**WELWYN HATFIELD BOROUGH COUNCIL
EXECUTIVE DIRECTOR - PLANNING, PUBLIC PROTECTION AND GOVERNANCE**

DELEGATED APPLICATION

Application No: 6/2017/2786/EM
Location: 28 Brockwood Lane Welwyn Garden City AL8 7BG
Proposal: Erection of single storey side and rear extension including alterations to openings
Officer: Ms Lucy Hale

Recommendation: Refused

Drawing No: 4247-P01 Revision: B

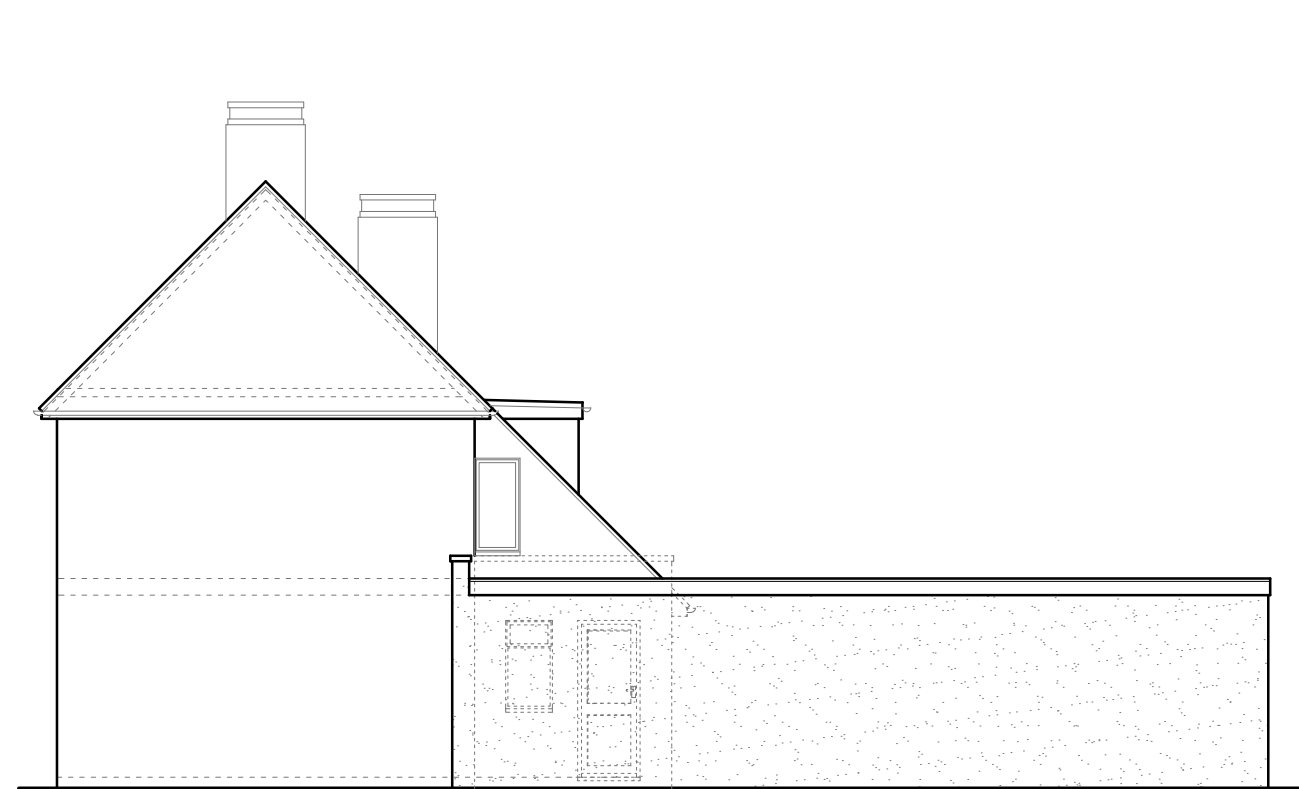
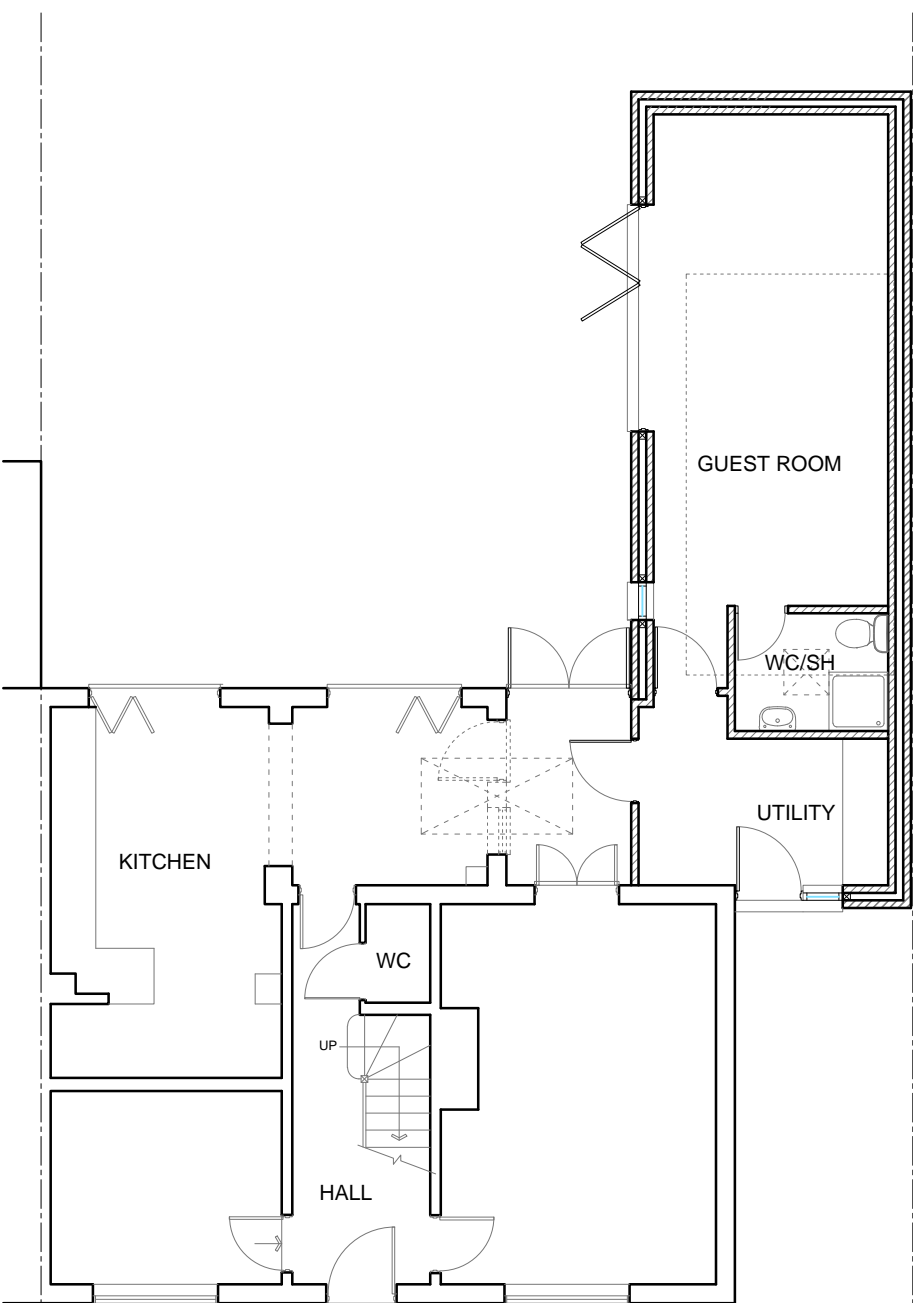
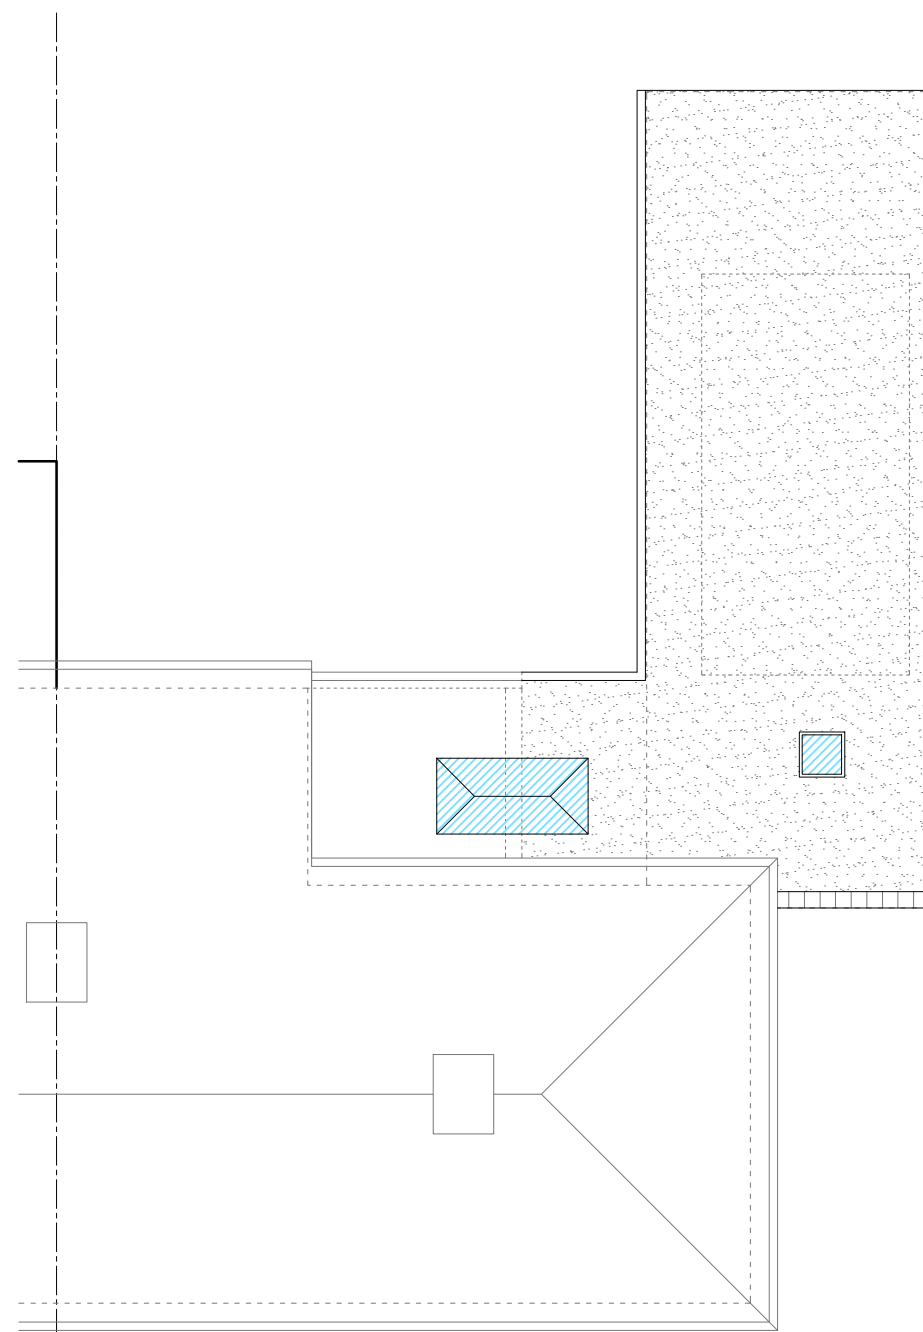
With regard to scale, the proposed extension is sizeable and would measure approximately 10.7 metres in depth and would create an 'L' shape along the side boundary of the site. Whilst it is noted there is an existing timber outbuilding within the site which sits within the proposed footprint, this is notably smaller in scale to the extension proposed. The outbuilding measures approximately 5.3 metres in depth by 2.7 metres wide, the proposed extension would double in depth at 10.7 metres and enlarge in width to 3.8 metres. When considered as an extension to the property, by virtue of the siting and size, it is not considered to respect or relate to the scale of the original dwelling and would result in an incongruous addition. The proposed extension would extend the built form significantly into the rear garden, eroding the special character of its environment.

It is considered that the proposal, by virtue of its scale and bulk, fails to maintain and enhance the amenities and values of the Garden City.

The extension would be built along the shared boundary with No.26 Brockswood Lane. Whilst the extension would extend some depth into the rear garden, it would be of single storey nature at a height of approximately 2.7 metres with a flat roof. As a result of the outbuilding, separation distance and boundary treatments, it is not considered that the extension would result in a detrimental impact on the residential amenity of this neighbouring occupier in terms of loss of light, overbearing impact or privacy.

The proposed rear extension, by virtue of its scale and excessive depth, would fail to appear

subordinate in scale and respect the design and form of the original dwelling. The proposed extension would result in an incongruous addition to the application dwelling which that would fail to maintain the amenities and values of the Garden City, contrary to Policy EM1 of the Estate Management Scheme.

1. The proposed rear extension, would result in an excessive depth of built form in relation to the original dwelling which would fail to remain subordinate in scale and respect the character and form of the original dwelling. The extension would result in an incongruous addition that would fail to maintain and preserve the amenities and values of the Garden City and therefore the proposed development would be contrary to Policy EM1 of the Estate Management Scheme.
